Thurrock Flexible Generation Plant

Deadline 2 – Applicant’s Response to the ExA’s First Written Questions

Figure 4.3: Annual-mean NO₂ Process Contributions (µg.m⁻³).

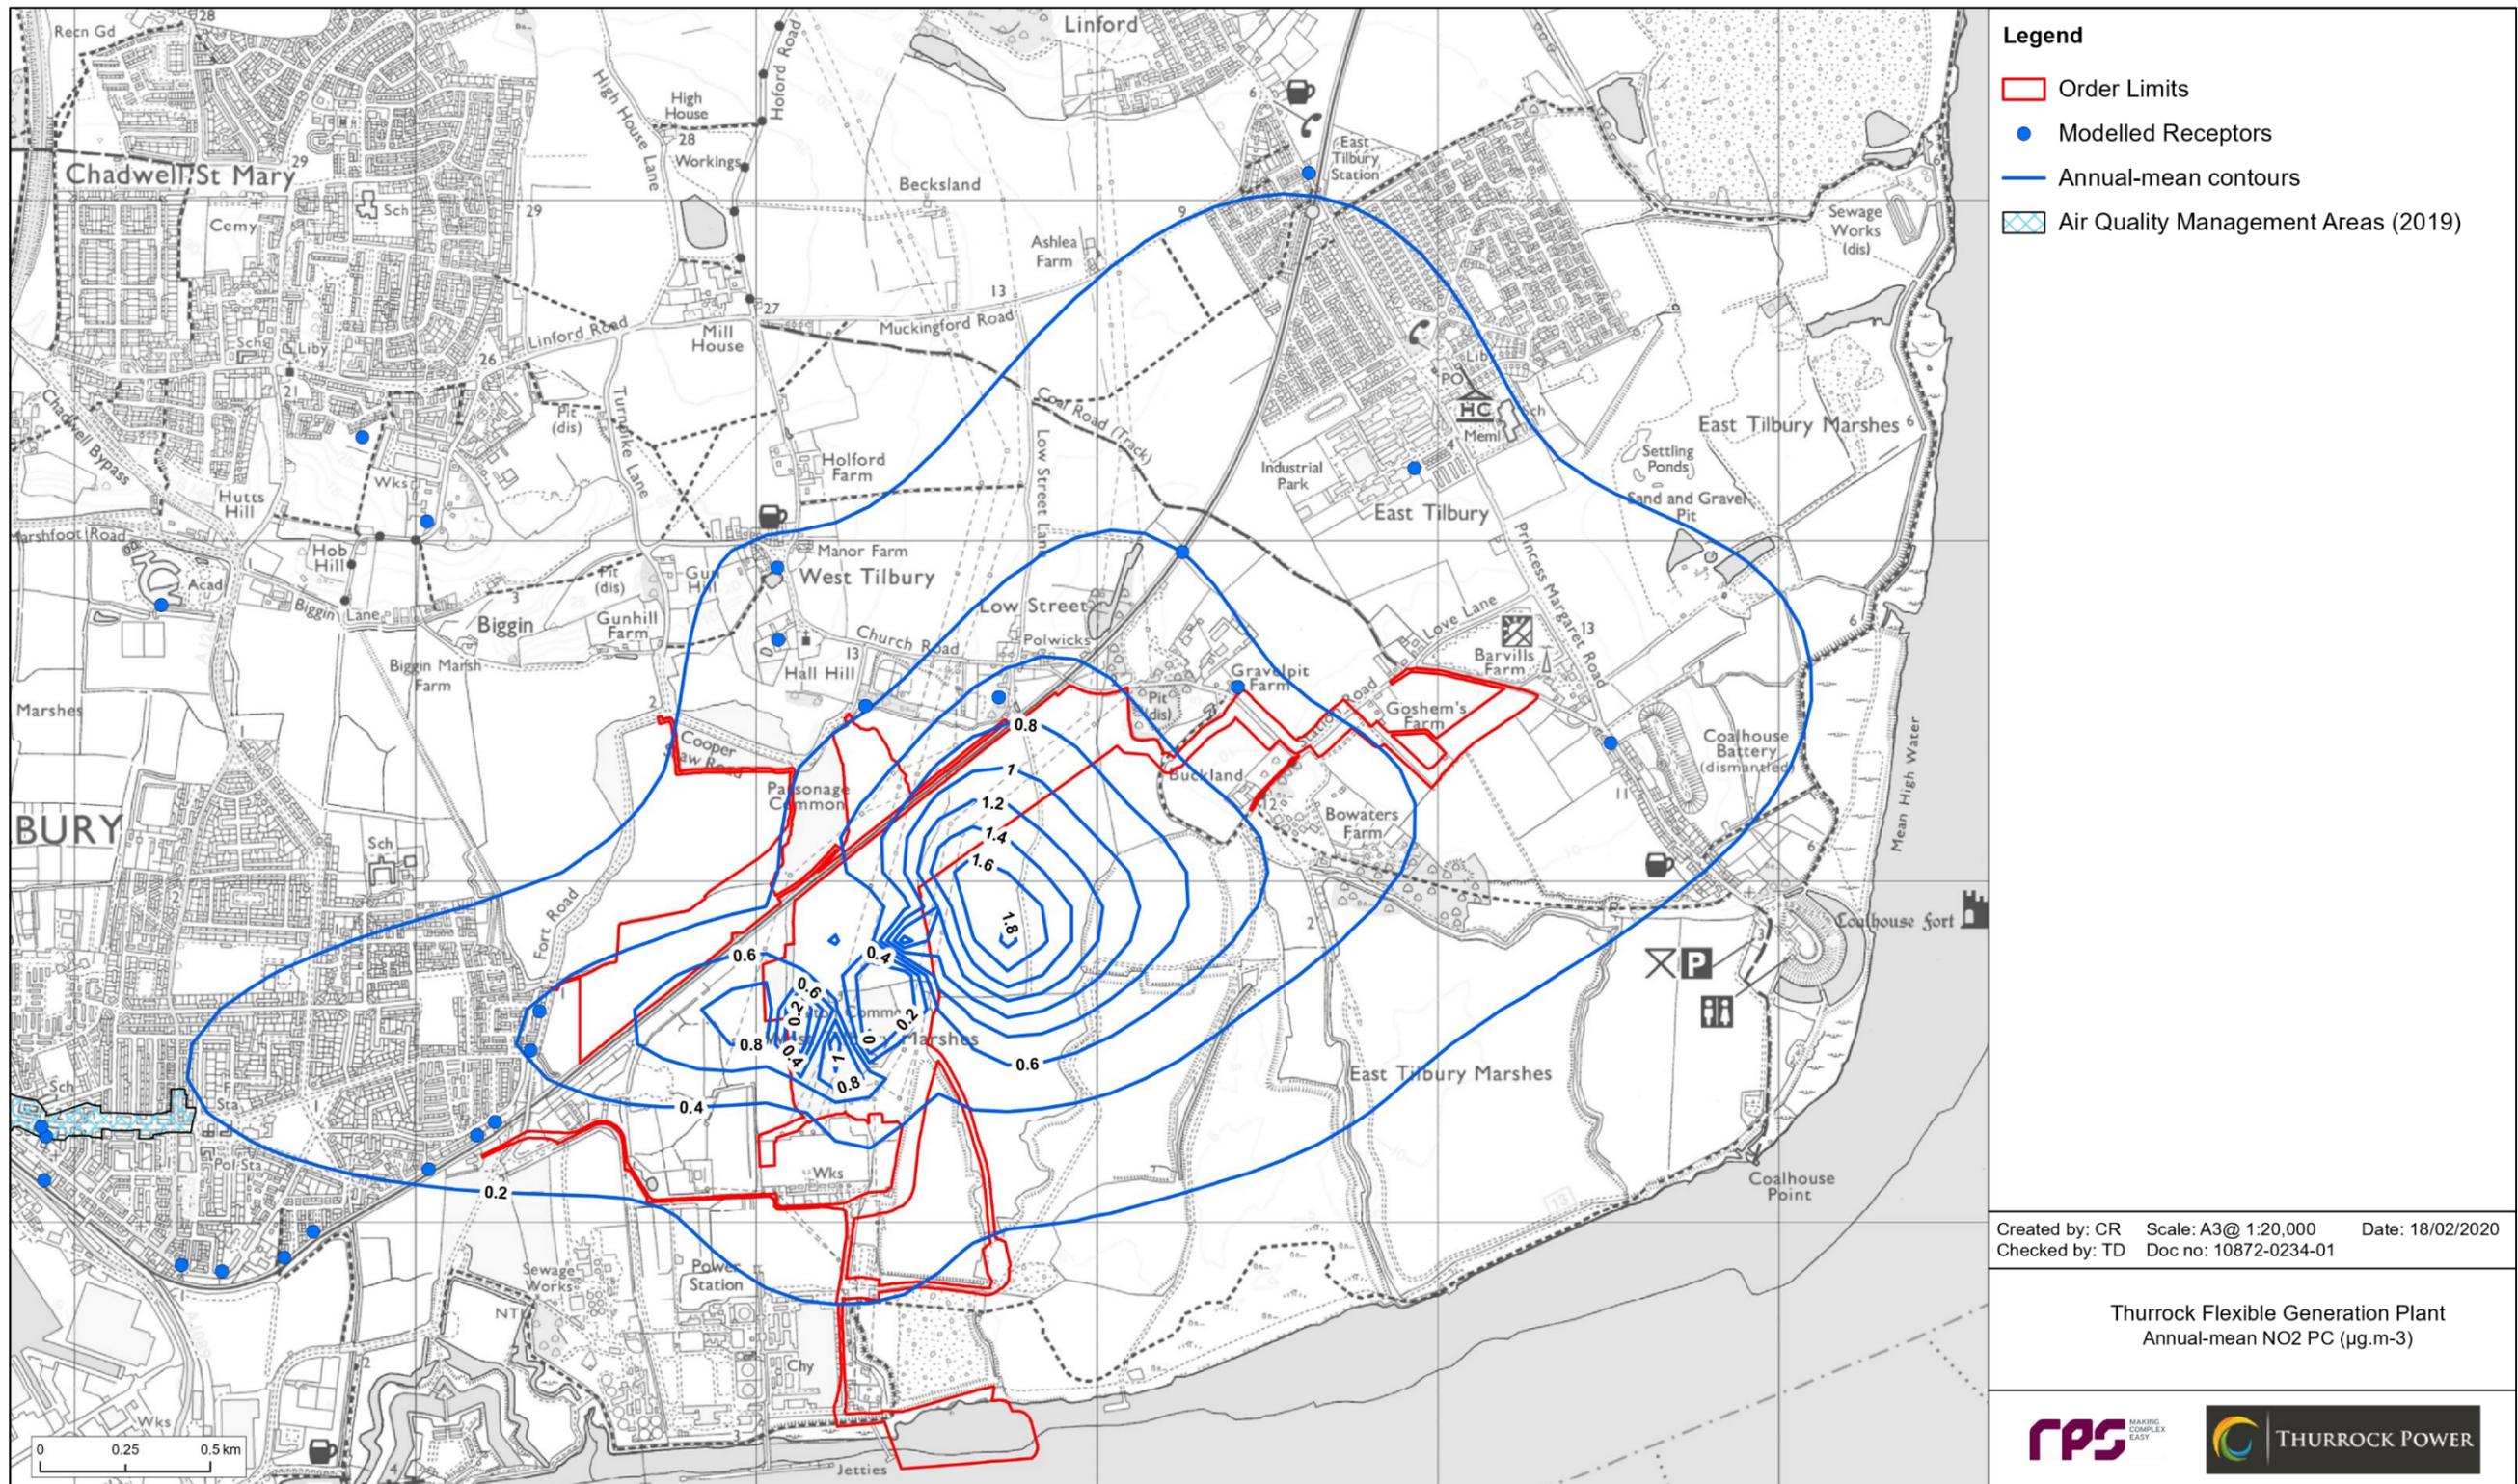
1.1.15	The annual mean NO ₂ concentrations at the receptors displayed in Table 4.5 do not appear to correspond to the concentrations presented in Figure 4.3. Similarly, the short-term NO ₂ concentrations at receptors in Table 4.7 do not seem to correspond to the concentrations presented in Figure 4.4. It is unclear how the data presented in ES Chapter 12, Tables 4.5 and 4.7 informs the ES Chapter 12, Figures 4.3 and 4.4; can the Applicant explain the relationship?	<p>Figure 4.3 and Figure 4.4 contained errors. The updated figures are enclosed in AQ-3. The concentrations presented in the tables in the report were correct and the conclusions were based on the data in the tables. The error was only in Figures 4.3 and 4.4.</p>
